Mallard Pass Solar Farm

**Applicant's Responses to
Interested Parties' Deadline 2
Submissions - Landscape and
Visual**

Deadline 3 - June 2023

EN010127/APP/9.24

DRAWING TITLE
Figure 6.6: Zone of Theoretical Visibility (ZTV) Study, Representative Viewpoints and Illustrative Viewpoints

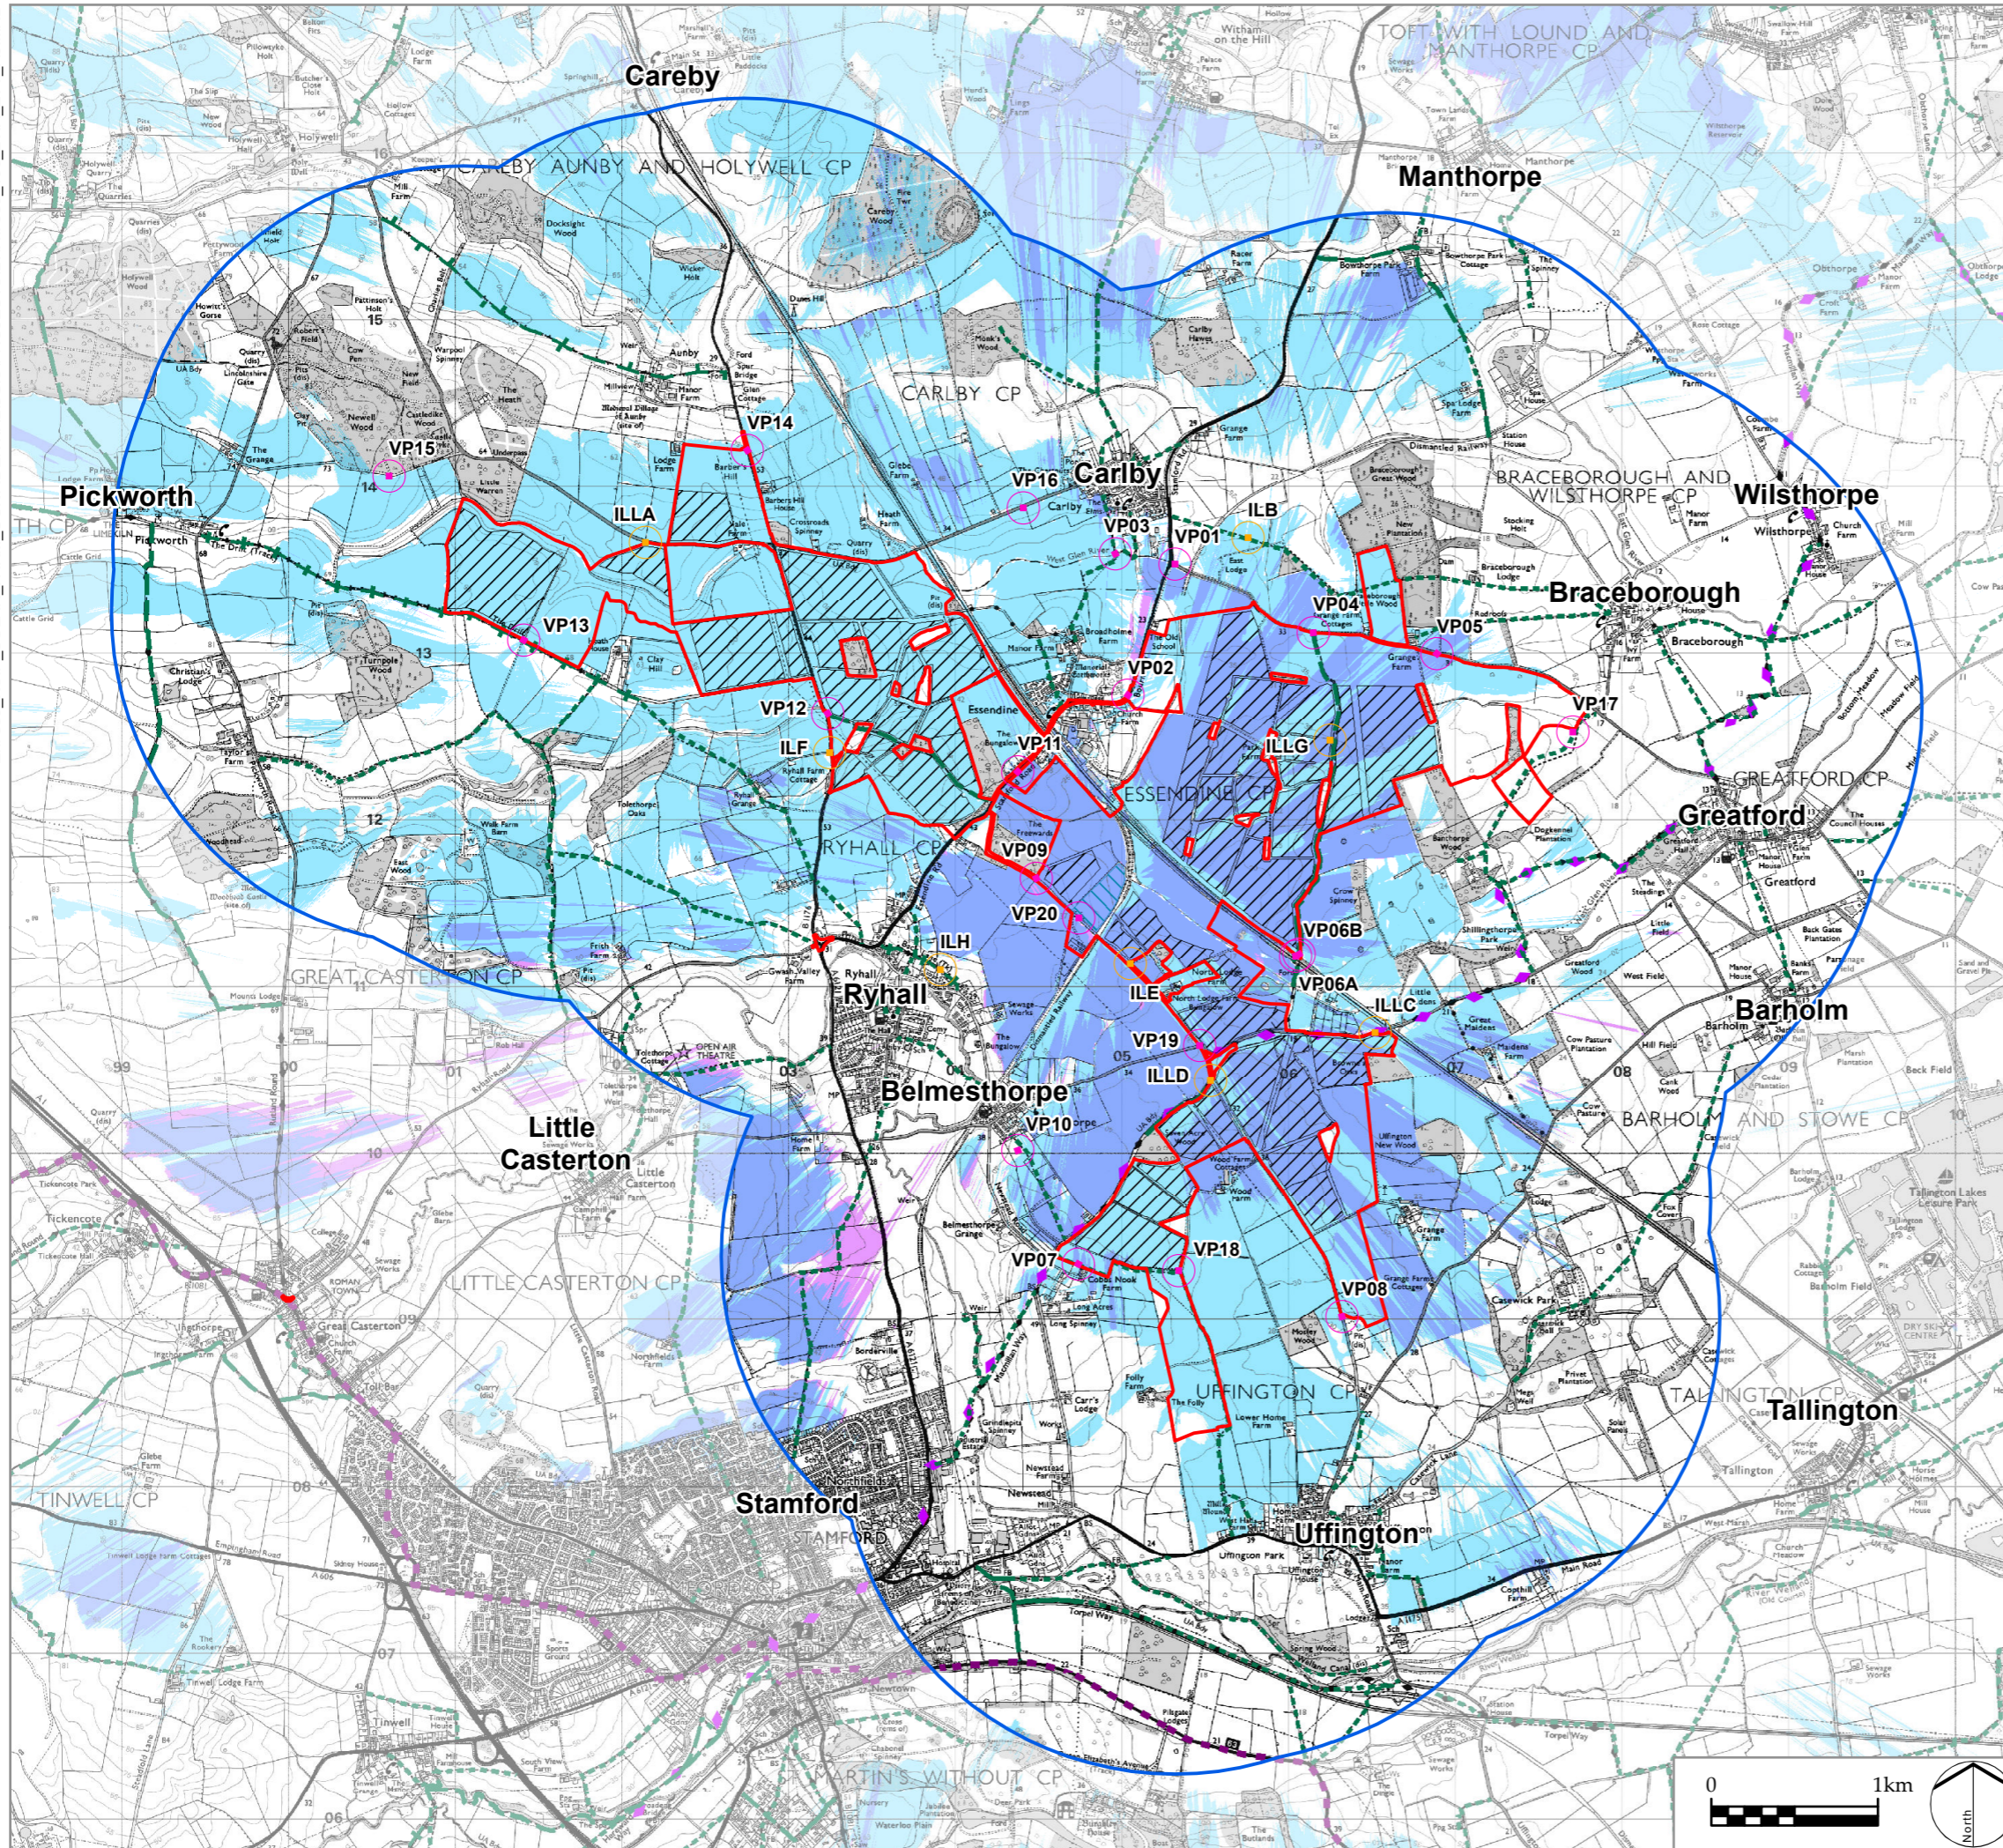
<p>REP2-044(LIR), REP2-045(FWQ), REP2-046(WR),</p>	<p>Validity of Viewpoints</p>	<p>Concern that no viewpoints have been selected beyond the 2km limit. Therefore, doesn't allow for potential impacts to the wider landscape to be assessed correctly.</p>	<p>The scope of the LVIA study area was agreed with RCC, SKDC and LCC.</p> <p>An initial 3km study area was used for production of the Zone of Theoretical Visibility (ZTV) plan submitted as part of the ES Scoping Report which was refined to a 2km study area following field surveys and observations and the likelihood of any significant effects occurring beyond 2km from the Order Limits.</p> <p>The Applicant notes that a 2km study area was also considered appropriate for other DCO solar applications including Longfield,</p>

<p>REP2-044(LIR), REP2-045(FWQ), REP2-046(WR), REP2-172</p>		<p>Challenge of the validity of the selected viewpoints.</p>	<p>As further explained in Row 8 above, the locations of the selected viewpoints were the subject of consultation with RCC, SKDC and LCC as outlined within Appendix 6.6 [AS-001].</p>
<p>REP2-044(LIR), REP2-045(FWQ), REP2-046(WR),</p>		<p>Concern that the most appropriate viewpoints were not chosen as part of this assessment. Appropriate viewpoint locations would have aided more in the assessment process.</p>	<p>As further explained in Row 8 above, the locations of the selected viewpoints were the subject of consultation with RCC, SKDC and LCC as outlined within Appendix 6.6 [AS-001].</p> <p>The selected viewpoints are considered to provide a proportionate range of views of the Proposed Development at different distances and directions from the Order Limits. The assessments within the LVIA are not in any event limited to the locations of the representative and illustrative viewpoints.</p>

Parties Raised	Sub-Theme	Issues Raised	Applicant's Response
<p>REP2-044(LIR), REP2-045(FWQ), REP2-046(WR),</p>		<p>Concern regarding the lack of rationale behind the choice of viewpoints. Further clarity is requested.</p>	<p>The locations of the representative and illustrative viewpoints were the subject of consultation via letter with LCC on 10th January 2022, RCC on 7th January 2022, and SKDC on 7th January 2022. Copies of these letters and correspondence to the relevant planning and landscape officers are contained within Appendix 6.6 [AS-001].</p> <p>The Applicant notes the importance placed on proportionality as advocated within GLVIA3 para 6.2 which acknowledges that viewpoints are representative and that it is simply not practical to capture all or every possible view that may arise from the Proposed Development.</p> <p>The representative and illustrative viewpoints are considered to provide a proportionate range of views of the Proposed Development at different distances and directions from the Order Limits. The assessments within the LVIA are not in any event limited to the viewpoint locations.</p>

Parties Raised	Sub-Theme	Issues Raised	Applicant's Response
			<p>Cleve Hill and Little Crow (all of which have been granted development consent).</p> <p>The locations of the representative and illustrative viewpoints were the subject of consultation via letter with LCC on 10th January 2022, RCC on 7th January 2022, and SKDC on 7th January 2022. Copies of these letters and correspondence to the relevant planning and landscape officers are contained within Appendix 6.6 [AS-001].</p> <p>A consultation response was received from AAH consultants on behalf of LCC on 5th May 2022 (TMO1) requesting the inclusion of a number of additional viewpoints. These viewpoints were subsequently included within the LVIA chapter as representative or illustrative viewpoints. No additional viewpoints were requested beyond the 2km study area by LCC at this stage in the process.</p> <p>The submission LVIA, therefore, includes 28 no. representative and illustrative viewpoints following consultation with LCC, RCC and SKDC. These representatives and illustrative viewpoints are considered to provide a proportionate selection of views at different distances and directions from the Order Limits, noting that the assessments within this LVIA are not in any event limited to these viewpoint locations.</p>
